From: Lorimer, Elliott <Elliott.Lorimer@lancashire.gov.uk>
Sent: 10 December 2020 18:59
To: Planning
Cc: Adam Birkett
Subject: Application 3/2020/0667

Please find comments below relating to the application ref 3/2020/0667 on behalf of the Forest of Bowland AONB Partnership:

Ground Floor Plan as Proposed
1:50 Scale

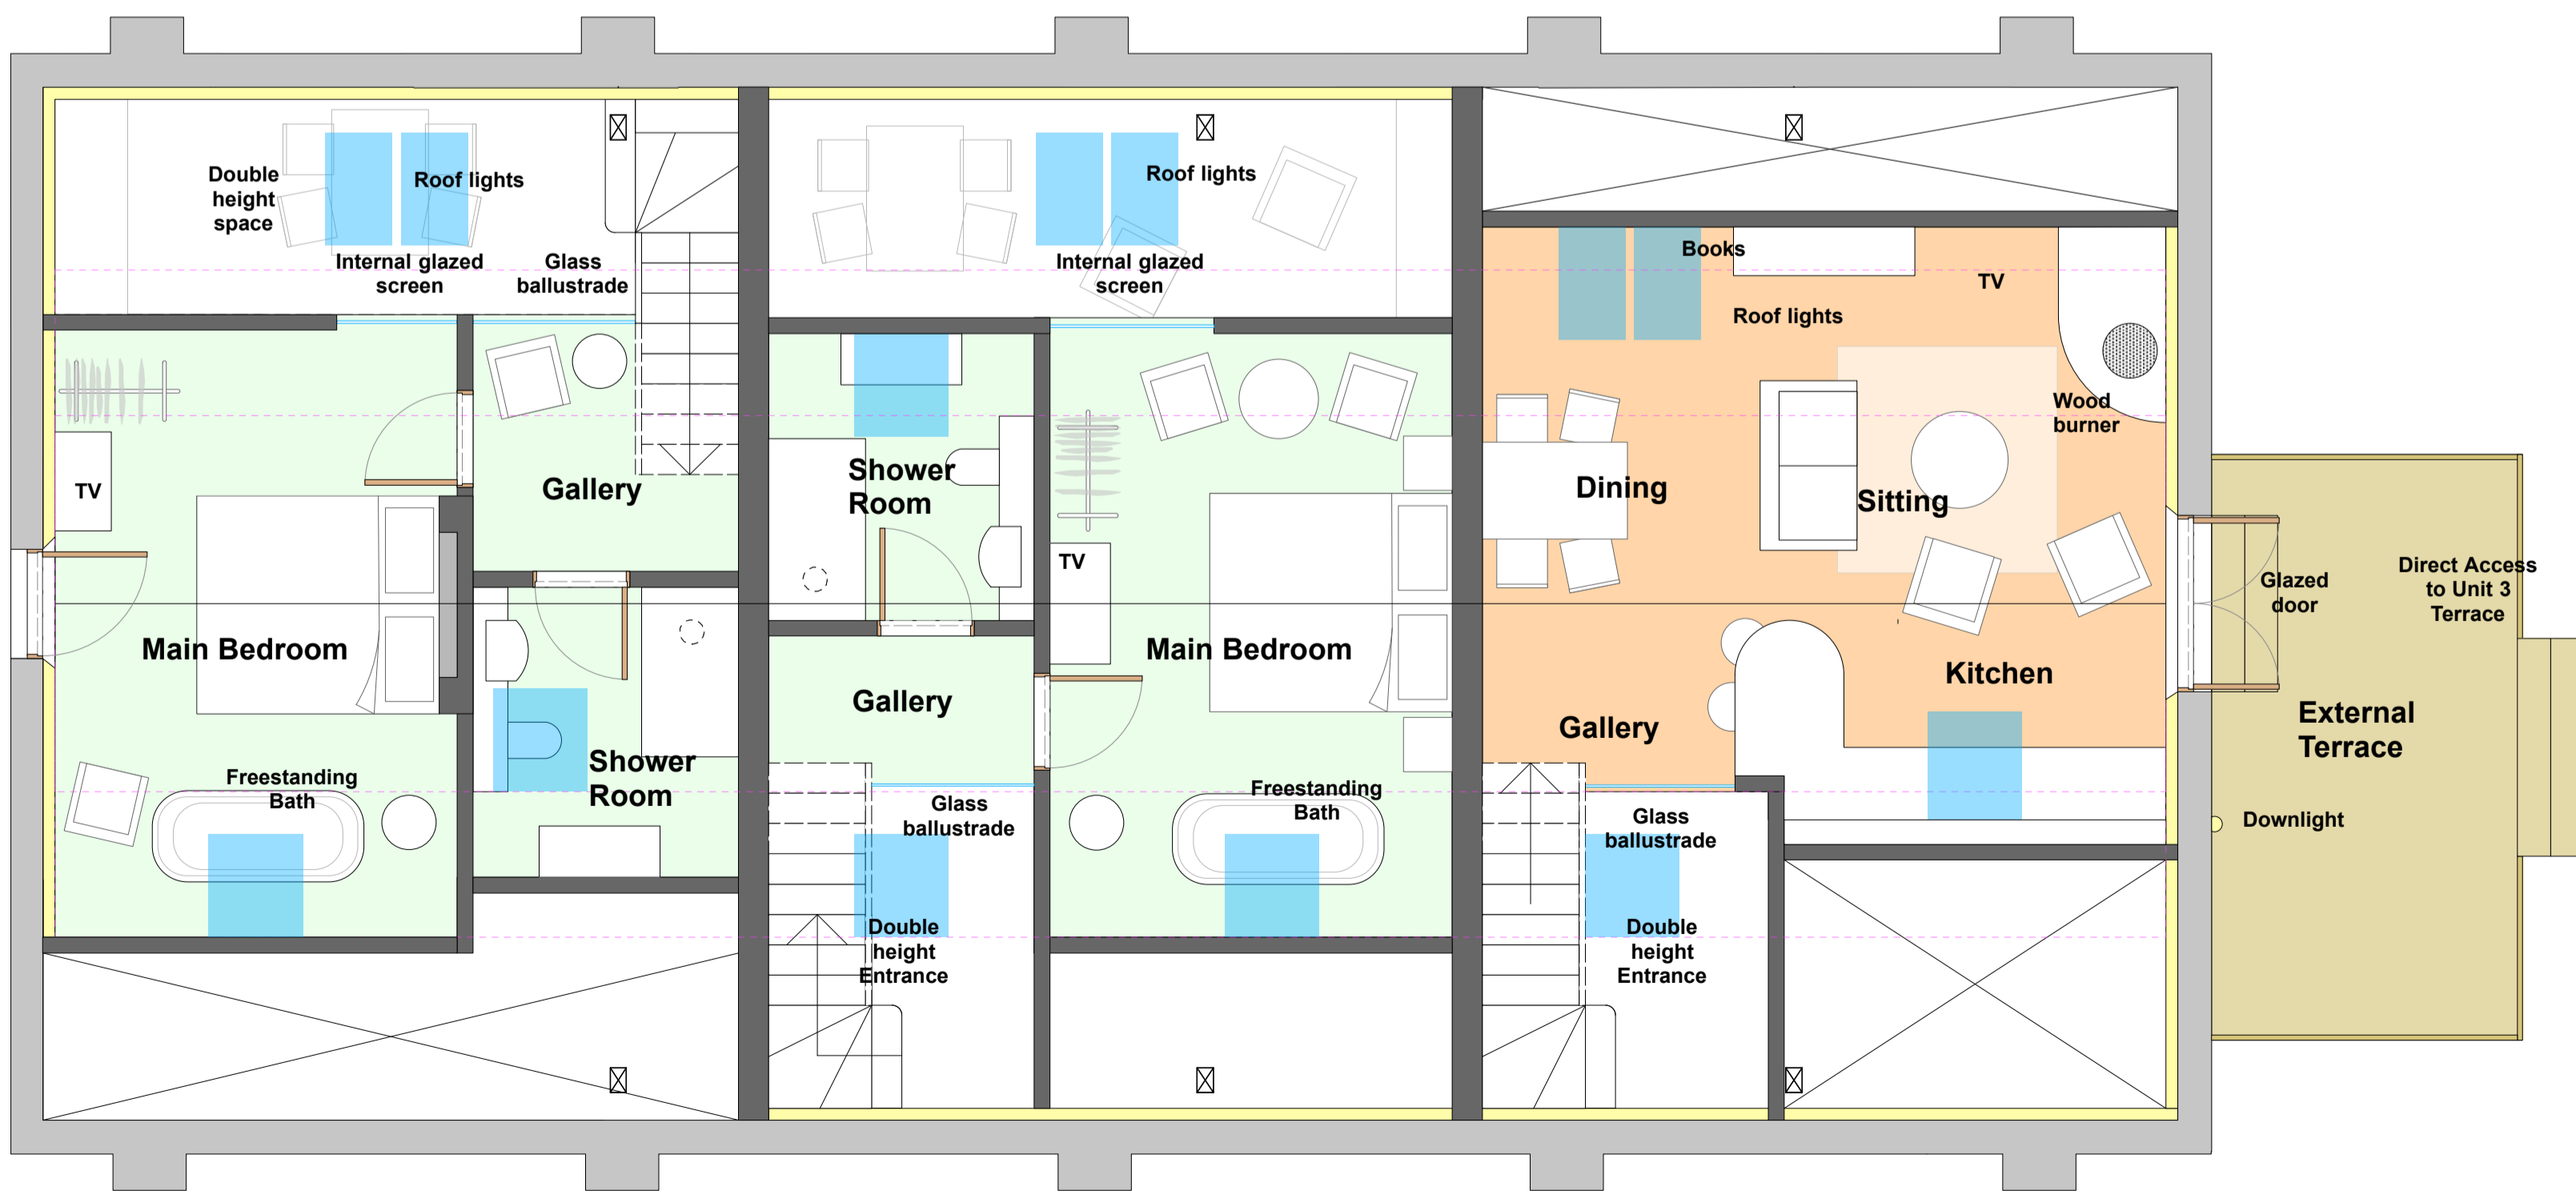
4. Similarly, the use by guests of a raised terrace external to the main building on the western elevation could have a similar effect to that outlined in 3. above.

5. The large area of glazing on the eastern elevation has the potential to create light spill from the building at night and potentially impact on the visual tranquillity and the darkness experienced in the Dunsop valley.

Site Plan as Proposed 1:200

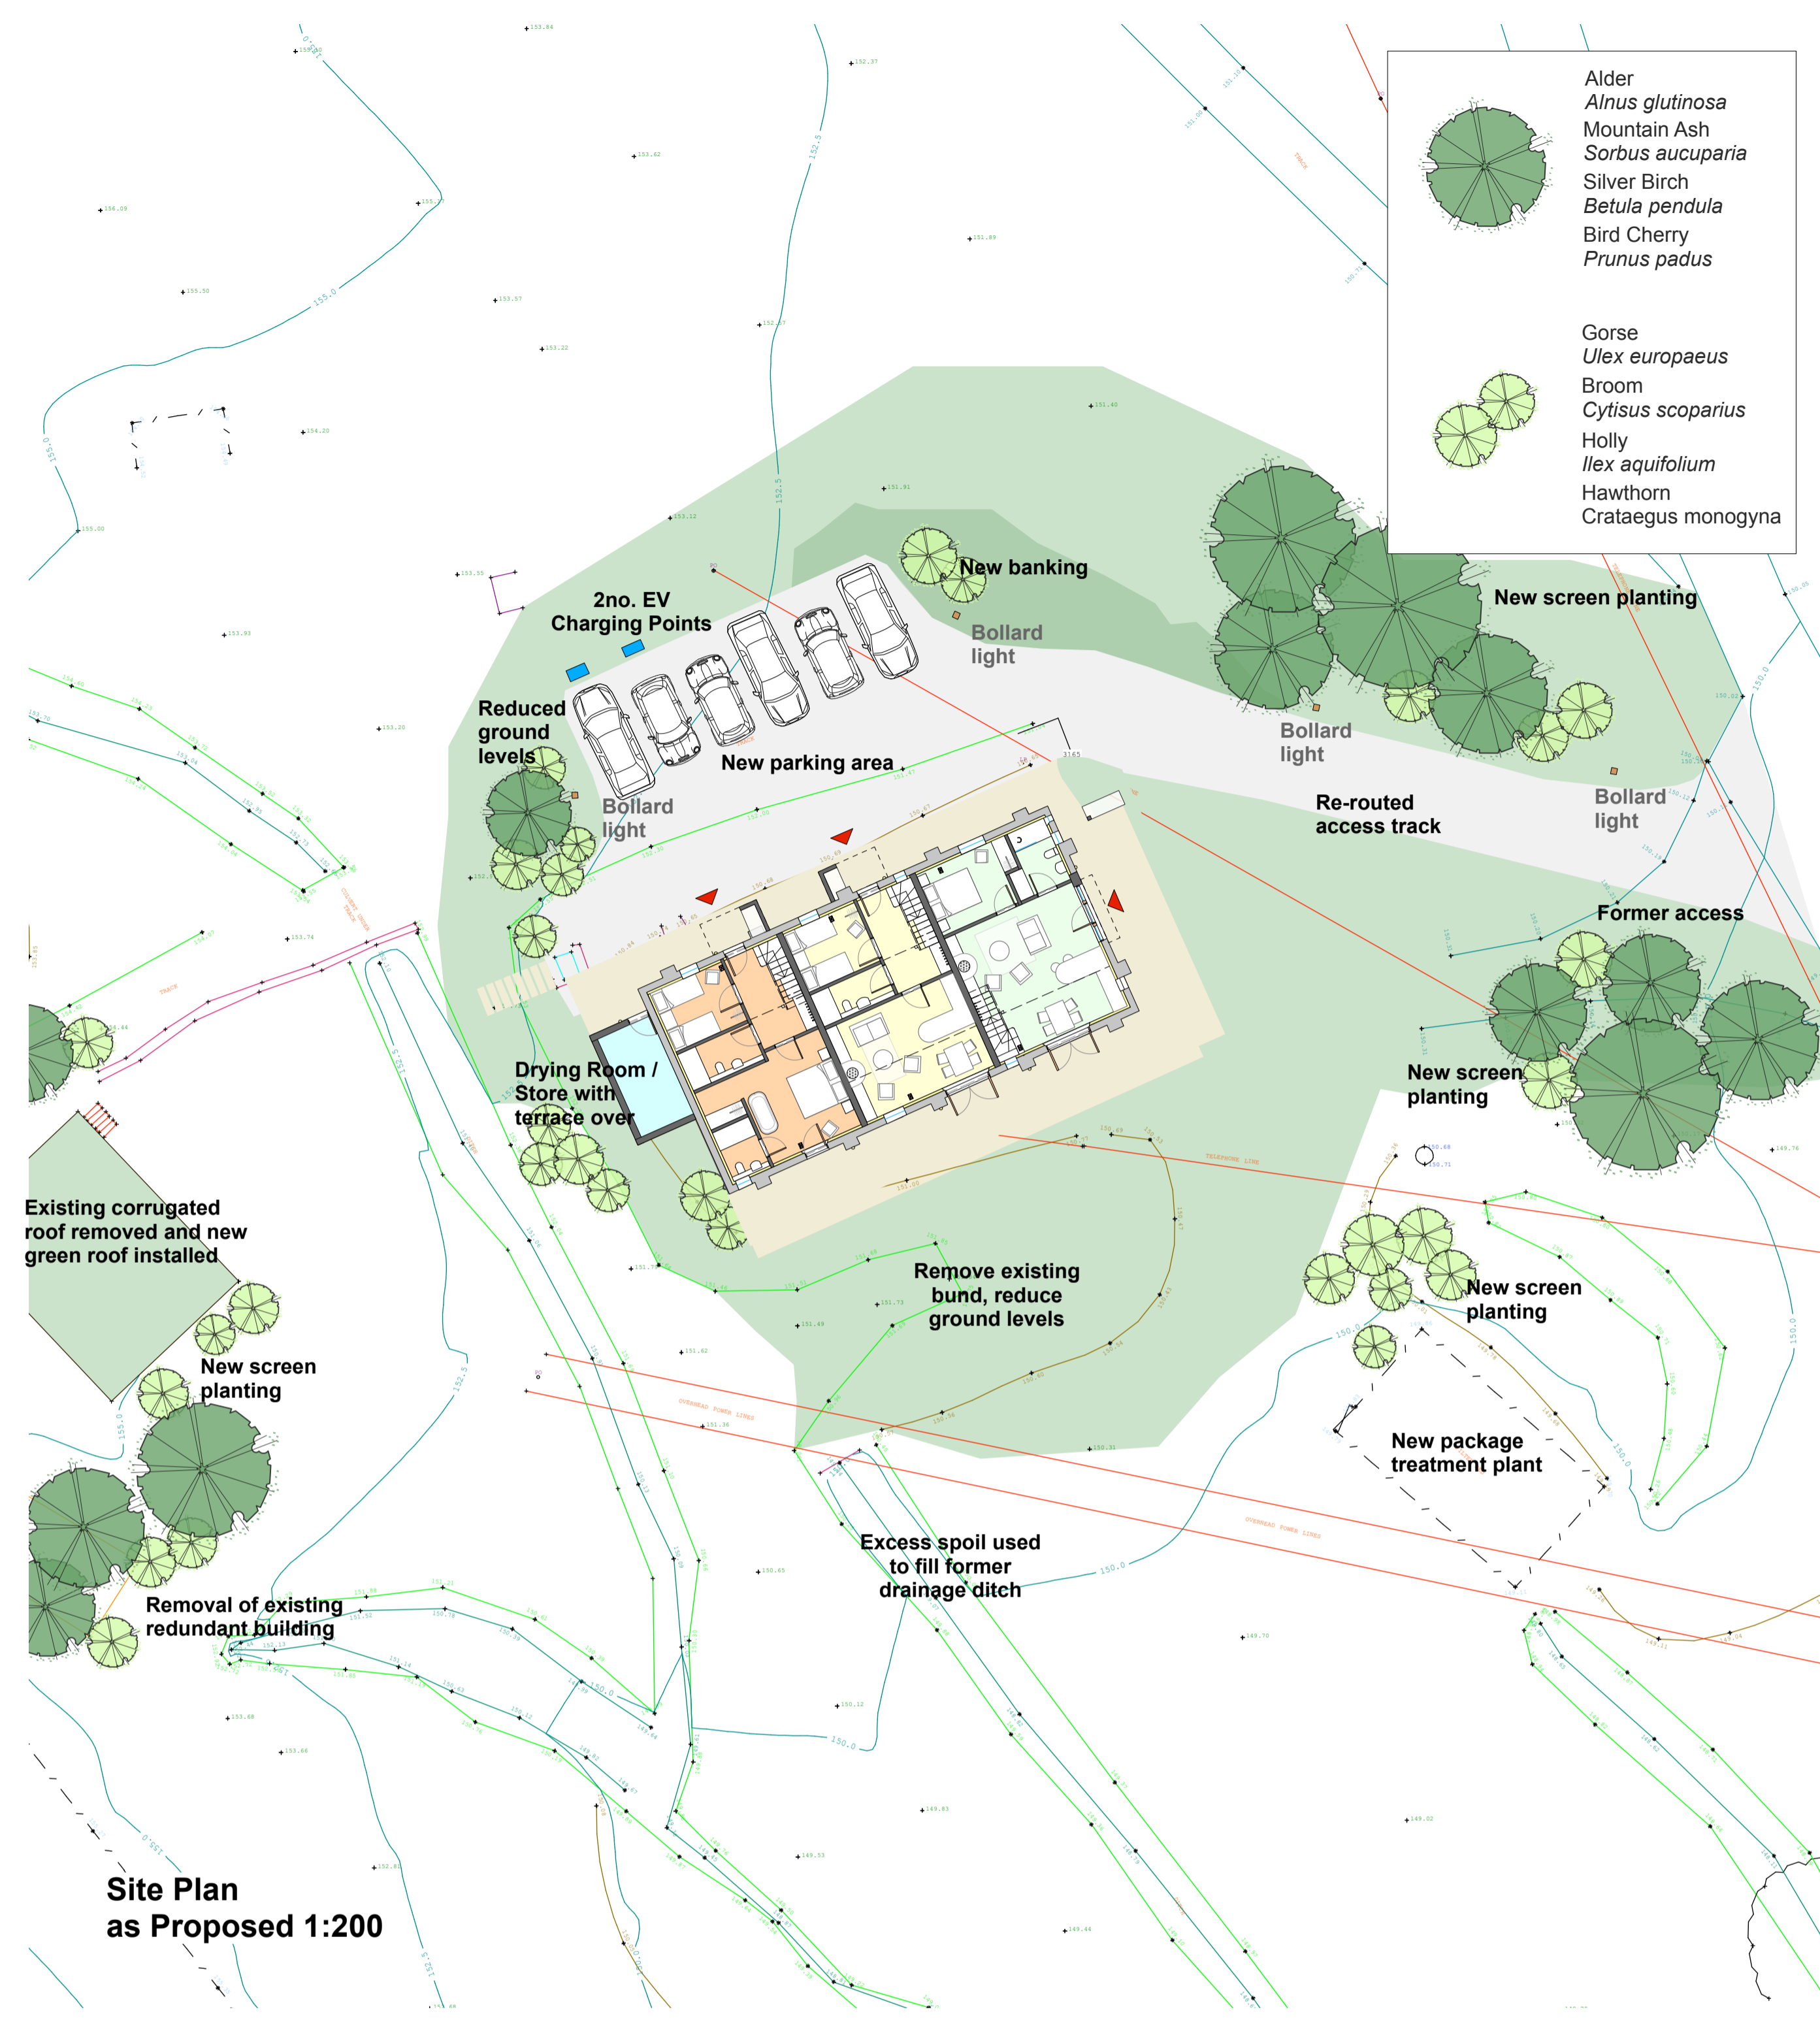
1. The applicant does not appear to have provided a detailed landscaping plan for the site. Currently, a limited site plan is provided in the 'Proposed Floor Plans'. However, this has only limited details of mitigation planting of trees and shrubs, but does not include detail on site levels following earthworks.

3. I have been unable to find details on the surfacing materials for the access track, car park and curtilage of the building on the eastern and southern elevations of the main hatchery building (these areas all appear in the same colour on the plan). There appear to be glazed doors with direct access to the southern elevation. It is unclear whether guests would be able to use this area as outside space? Such use could have the potential to introduce an incongruous element to the local landscape and impact on the tranquillity of the wider locality.
